From:Archer, Heather
Sent:14 Nov 2019 03:55:24
To:planning.comments@sevenoaks.gov.uk,
Subject:14.11.19 response DSTL Fort Halstead, Crow Drive, Halstead, Sevenoaks, Kent TN14 7BU Planning Application 19/05000/HYB
Attachments:image001.png,

Site: DSTL Fort Halstead, Crow Drive, Halstead, Sevenoaks, Kent, TN14 7BU

Planning Application No: 19/05000/HYB

Highways England ref: 86207

Figure A2: Location of Feed Points used for Traffic Assignment

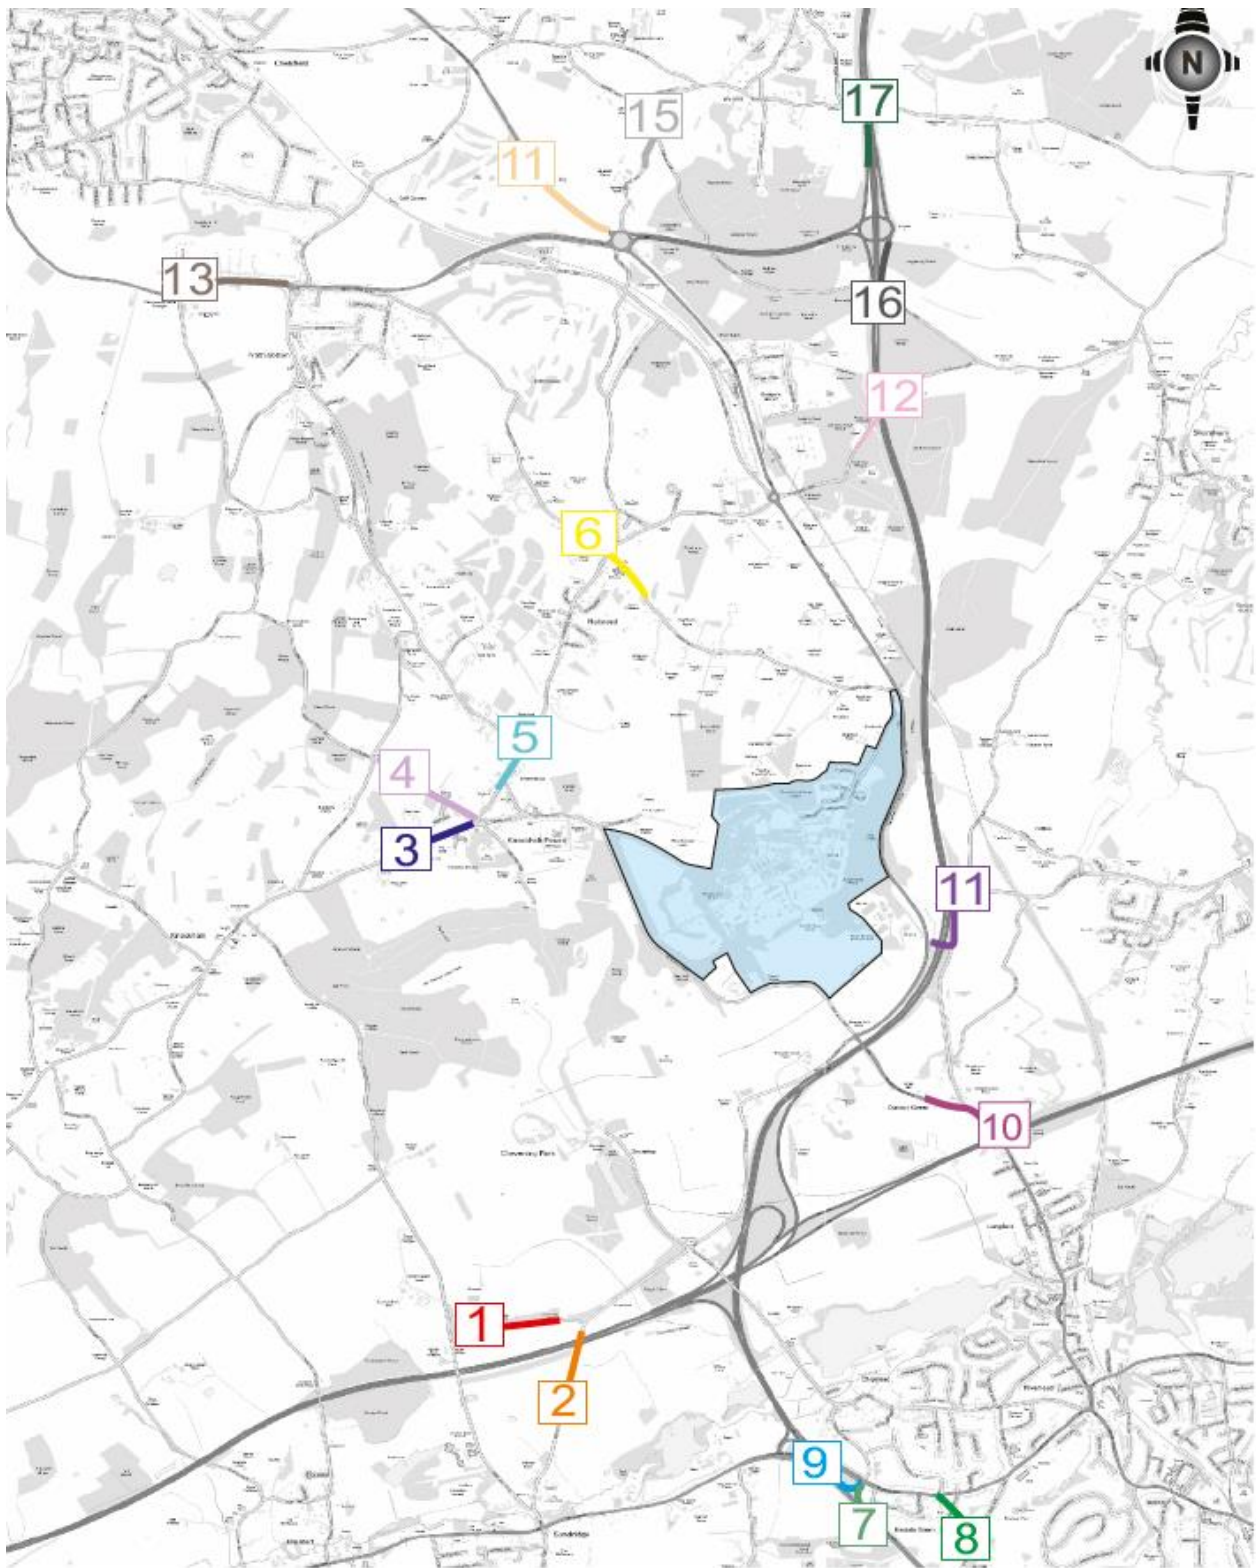
2. Highways England are not clear on the applicant's trip distribution and assignment. Please could we have a description of what location each numbered feeder point in tables 5.8 and 5.9 refers to?
